### PLANNING APPLICATION CONSULTATION RESPONSE

<b>Application Number:</b>	3/2022/0588
<b>Proposal:</b>	Discharge of Conditions 10 (Surface Water Drainage) and 11 (Surface Water Pollution Prevention) of planning application 3/2021/0076.
<b>Location:</b>	Queen Mary Terrace and Bridge Terrace, Mitton Road, Whalley, BB7 9JS

EXCEEDANCE ROUTE
LAYOUT

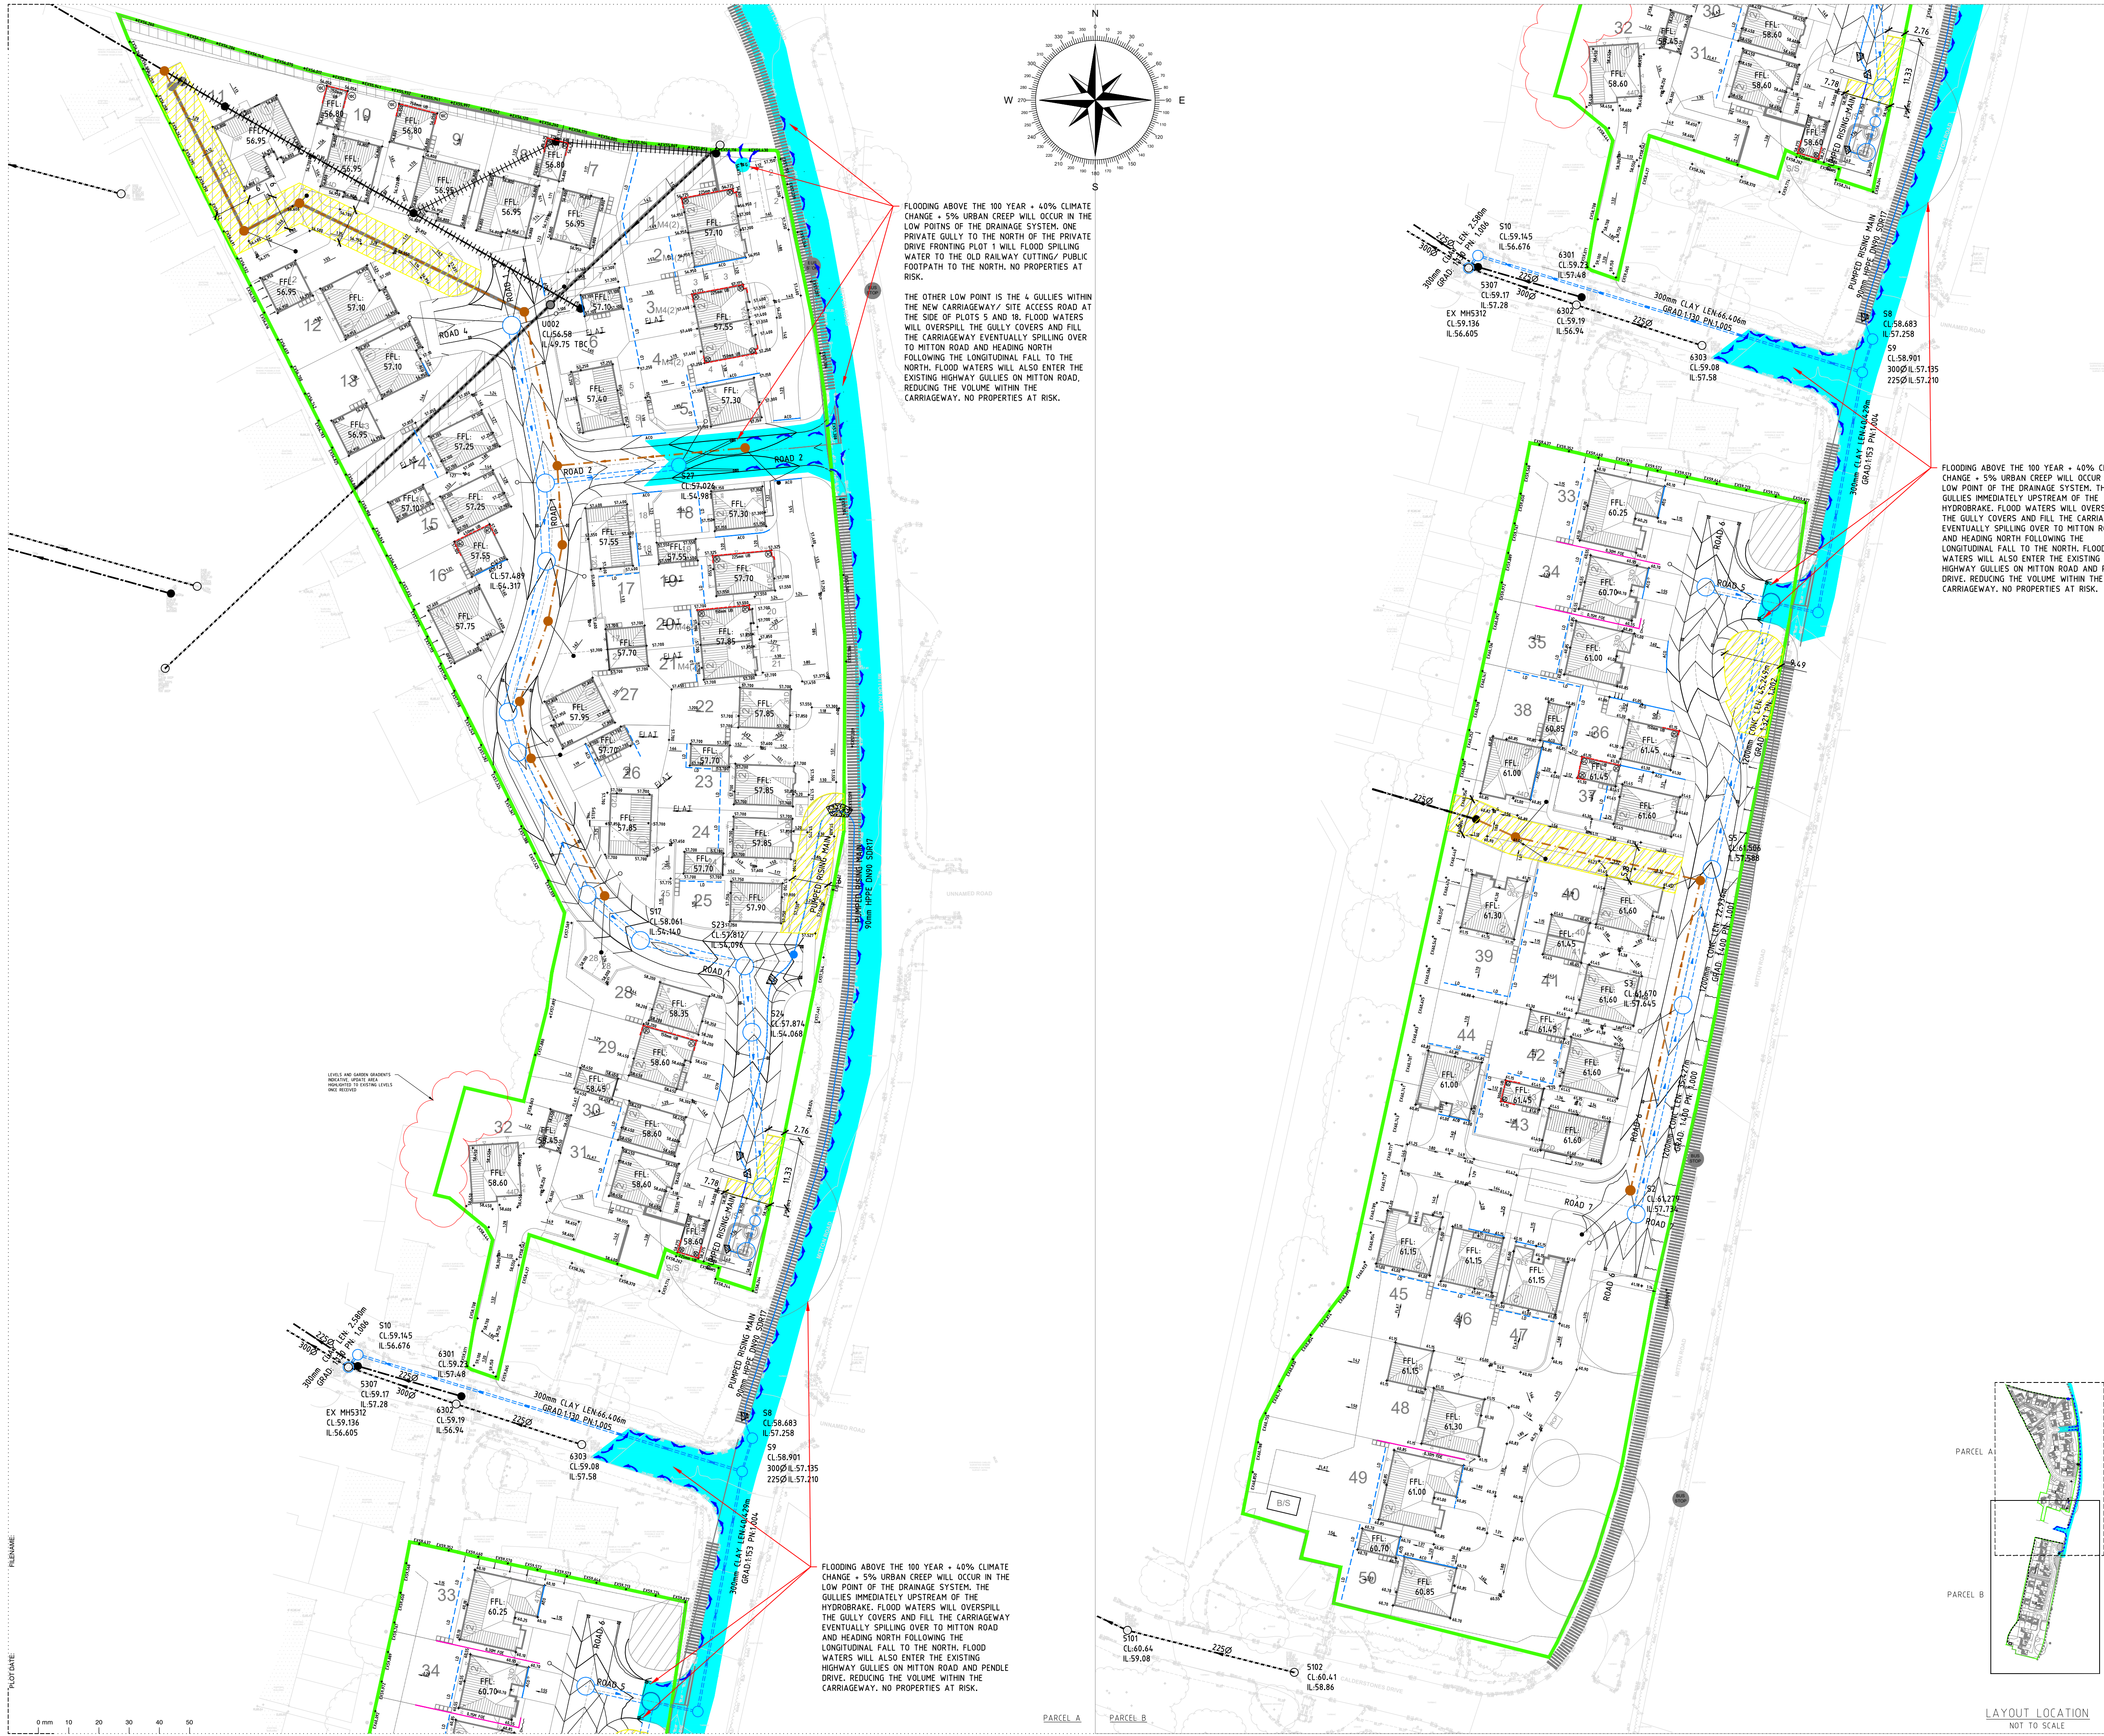
- The applicant has stated that the requirement for flood exceedance routes is not applicable in this sense as 'there is no flooding across the site for the 100-year storm'. The applicants drainage calculations however demonstrate a areas that are at risk of surcharging or of flood risk, therefore it is important that the development has been designed so that in the event of surface water flooding, which could for example occur from the drainage system , the site has been developed so that flows exceedance flows are directed away from the areas of

2 being most vulnerable and the finished floor levels have been taken into due consideration with these flow paths. Flood Exceedance routes are to assess the post development surface water flow paths that will occur as a result of any rainfall event that exceeds the 1 in 100 year (+40% CC), or as a result of the drainage system blocking/failing.
